Gatwick Airport Northern Runway Project

Examination Ref: TR020005

Joint Local Authorities' Response to the Applicant's Deadline 8 Submissions

Deadline 9: 21 August 2024

Drawn date:
September 2023

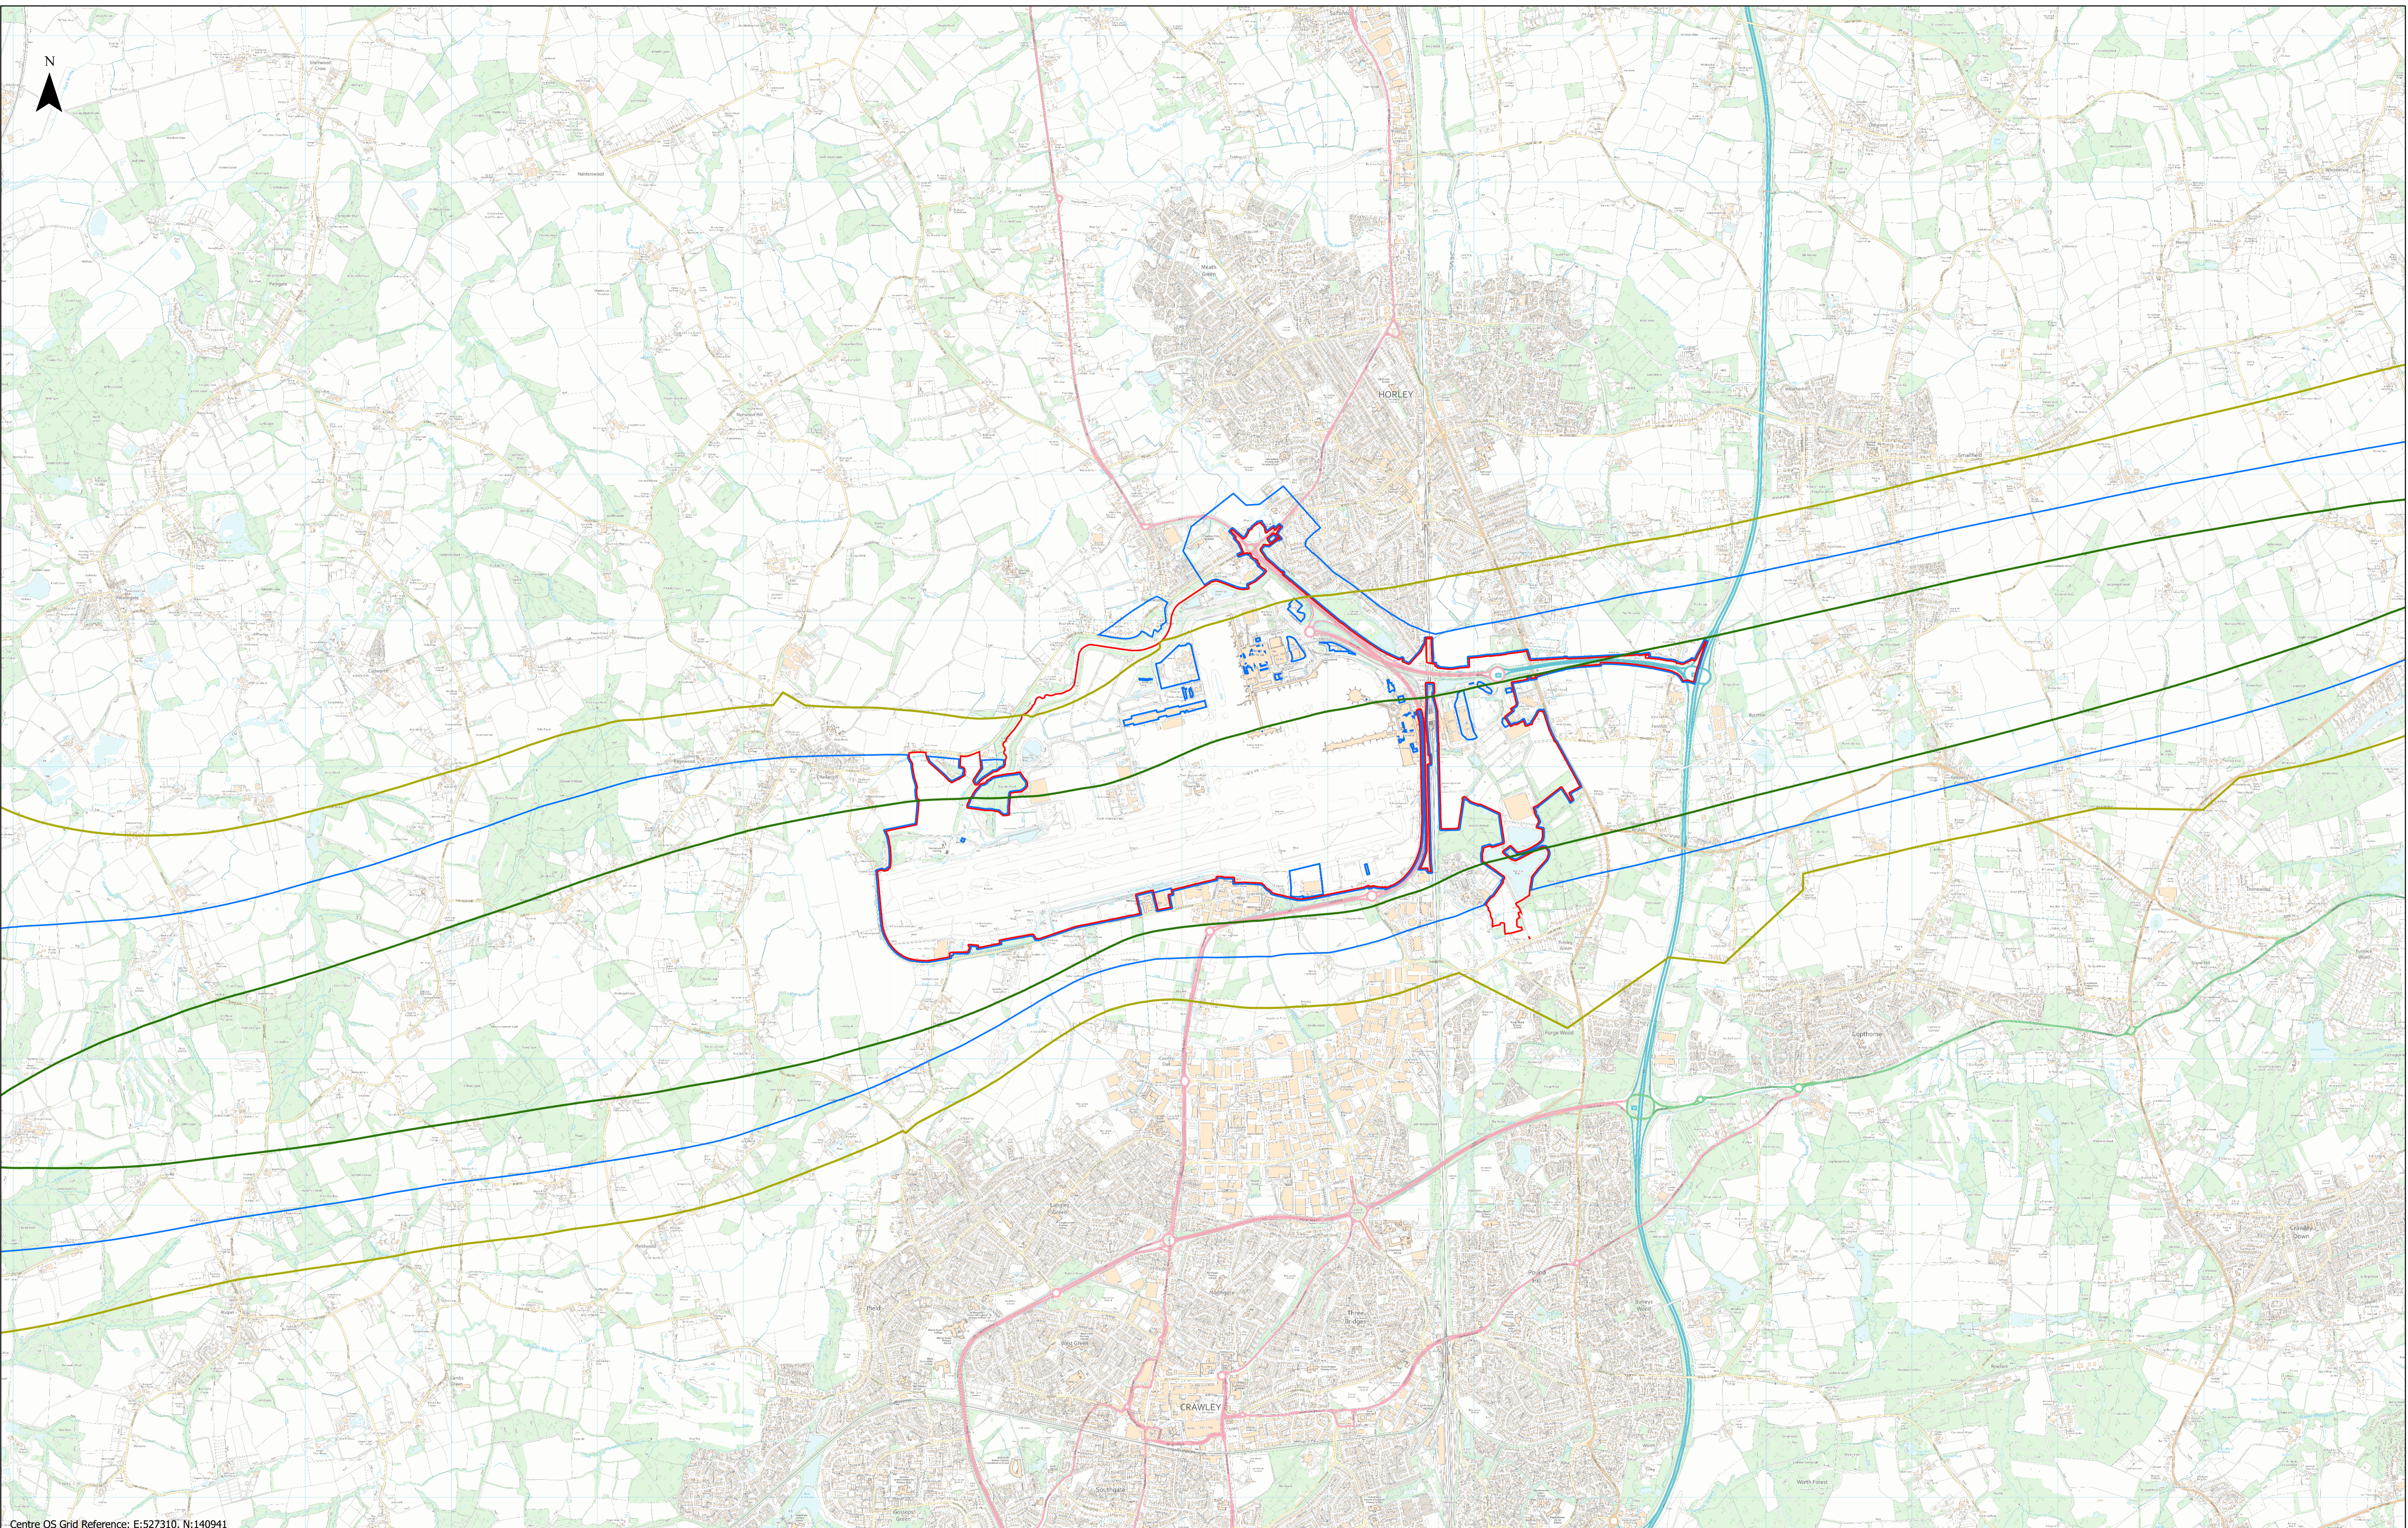
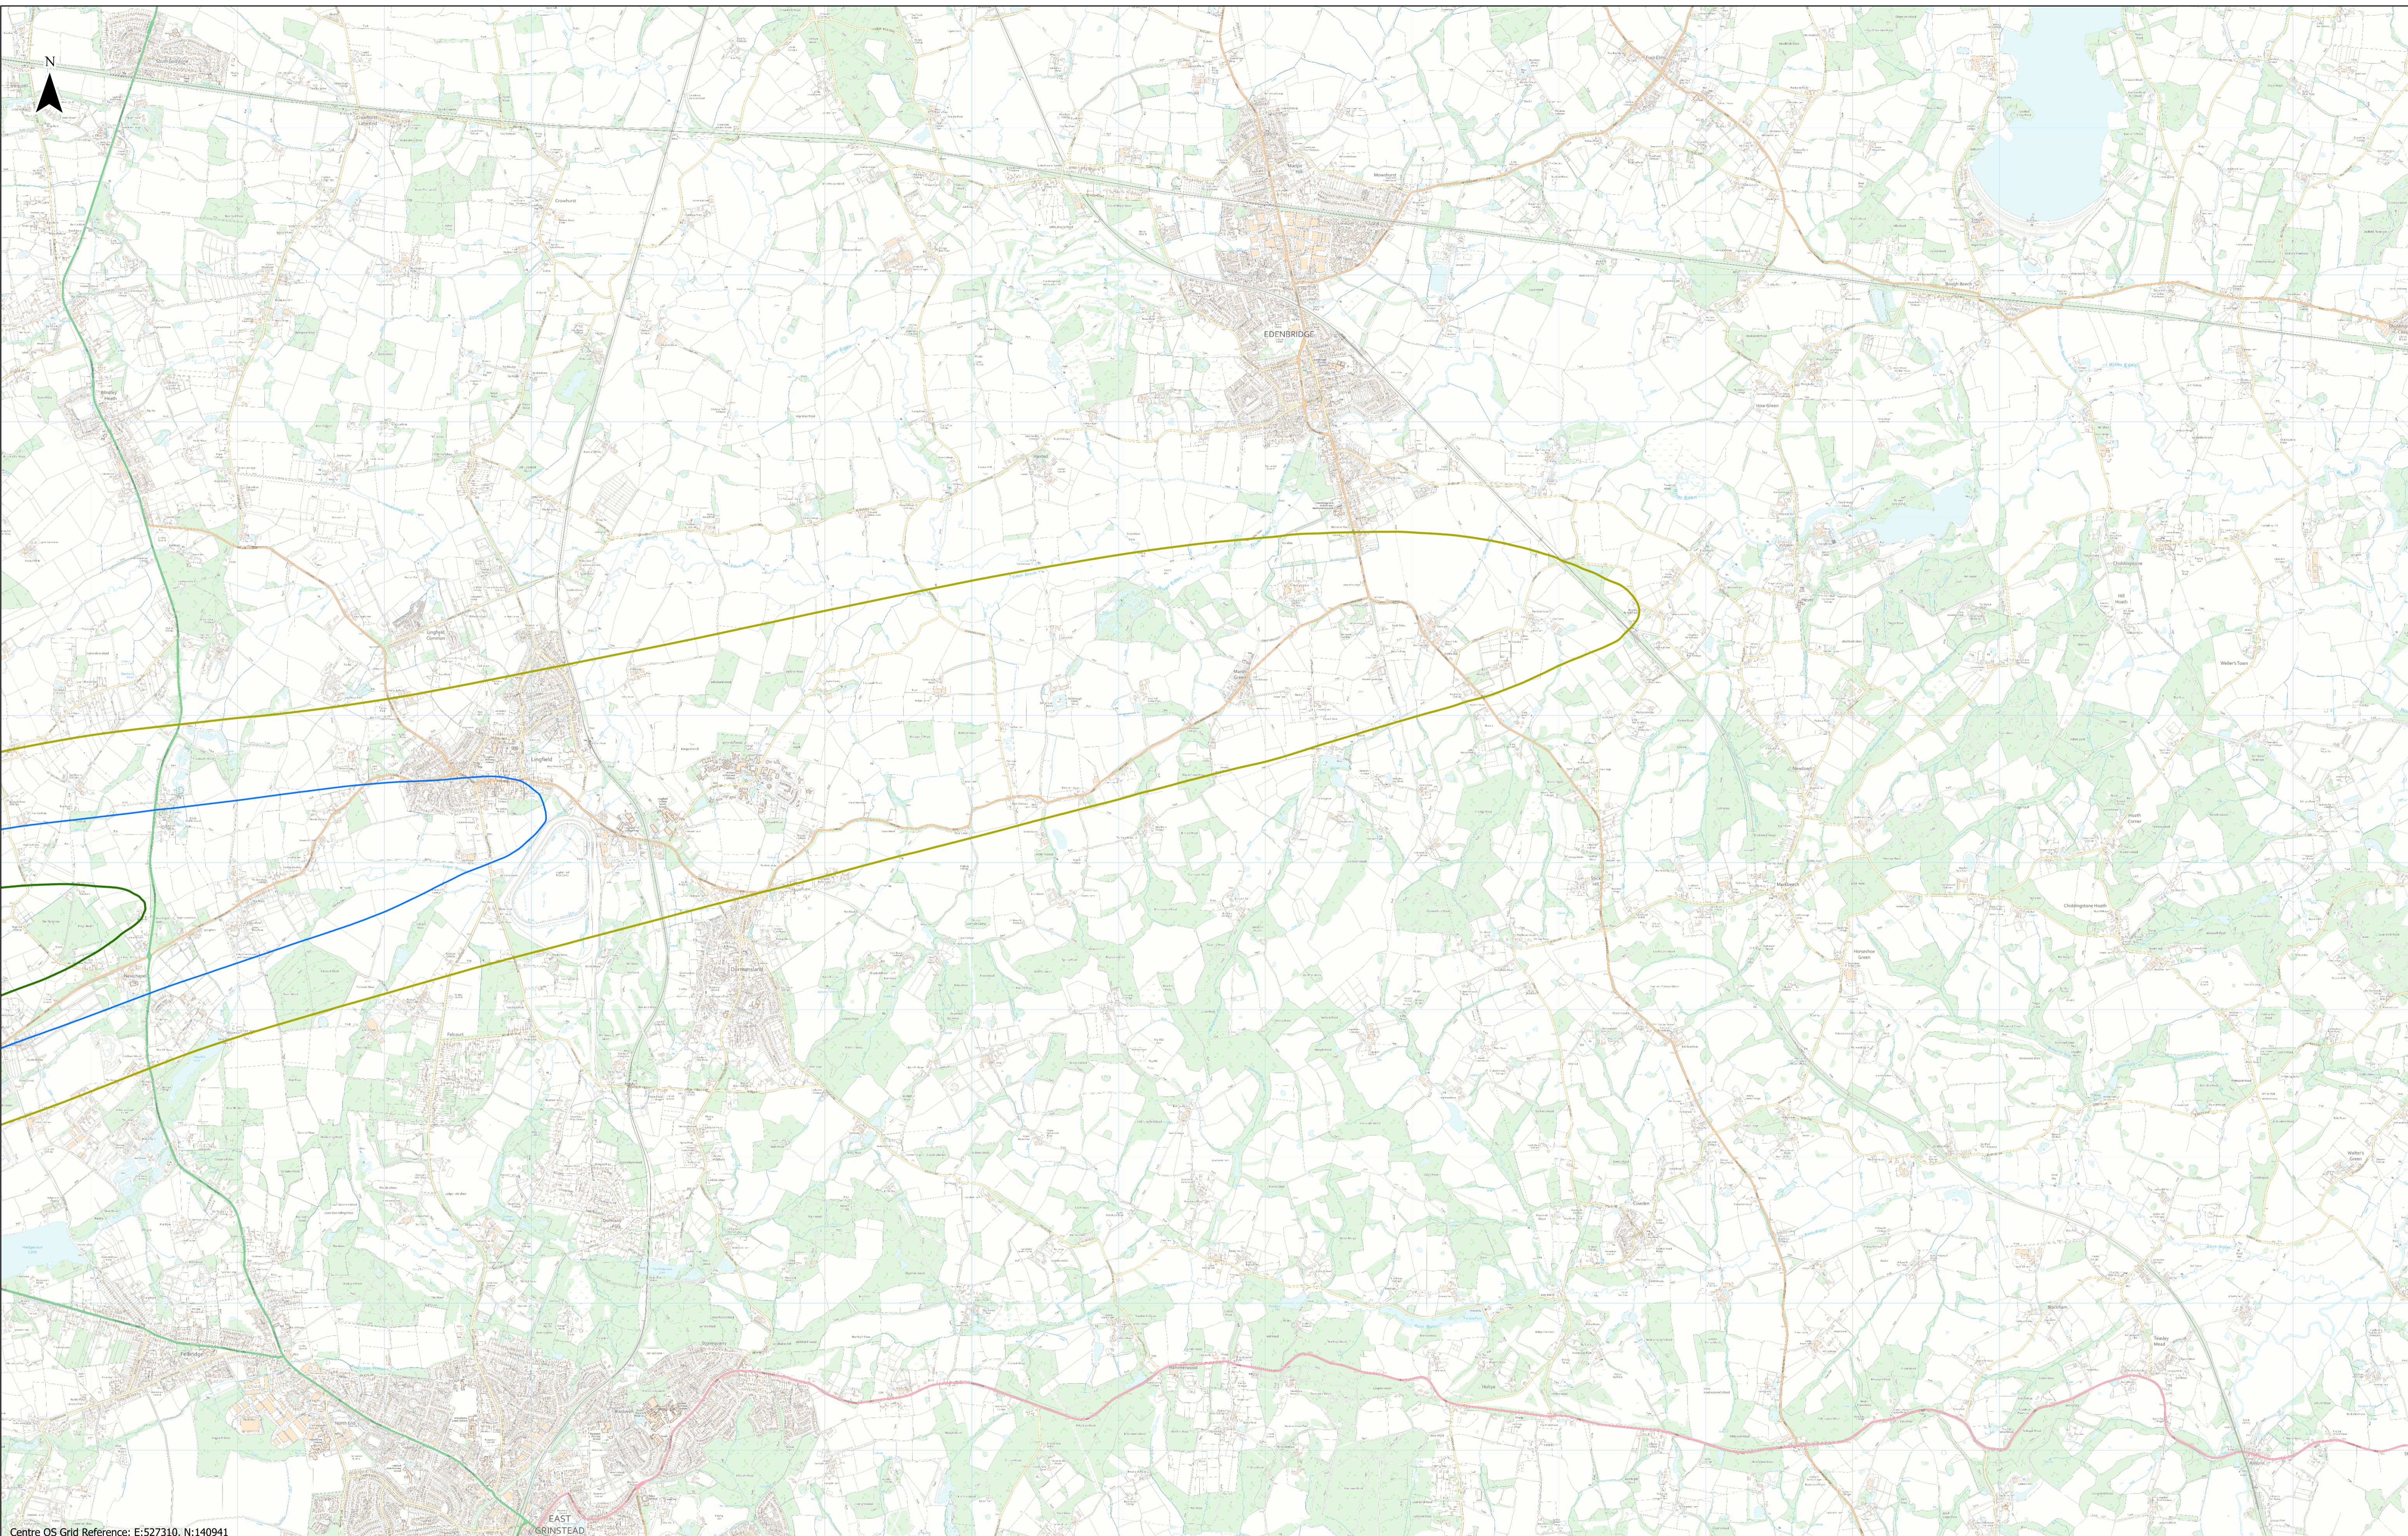
- 4.1 The Applicant has confirmed their proposals on the division of the outer zone, timings on delivery of the works, the use of the updated central case fleet and some minor further proposals for installation of thermal insulation in loft space.

- 4.2 The JLAs do not consider that the scheme satisfactorily addresses acoustics, ventilation and overheating and that harmful exposure to noise is likely to occur, as are other potential health effects and that the comments in [\[REP5-094\]](#) are still valid.

- 4.3 Importantly, any property qualifying for noise insulation must have an overheating assessment performed and an insulation scheme designed to ensure that there is an appropriate internal living environment.

- 4.4 The scheme takes no account of protecting those people who are within one additional noise induced awakening contour that the JLAs maintain is a significant observed adverse effect level and have discussed in some detail in [\[REP1-068\]](#),[\[REP1-100\]](#), [\[REP7-103\]](#), [\[REP8-161\]](#).

- 4.5 The one additional noise induced awakening contour should be treated as a primary metric and the Applicant still needs to provide full set of contours for this information and update the noise insulation scheme accordingly.

- 4.6 The scheme continues to operate on an average mode contour. The JLAs continue to believe that whilst this has some provenance given

the magnitude of effects on people living in the area and by reference to the Airports National Policy Statement para 5.68 it is reasonable to secure the noise insulation scheme on the basis of single mode contours.

- 4.7 The scheme inadequately assesses and make provision for dealing with the effects of ground noise between SOAEL and LOAEL and the cumulative impacts of air and ground noise on a predictive basis.
- 4.8 The JLAs welcome the proposals by the Examining Authority to consider cumulative and individual impacts of air and ground noise to the thresholds proposed. The JLAs cordially request that the Examining Authority reviews their position and includes the one additional noise induced awakening within their proposed scheme to ensure that all effects are properly addressed.
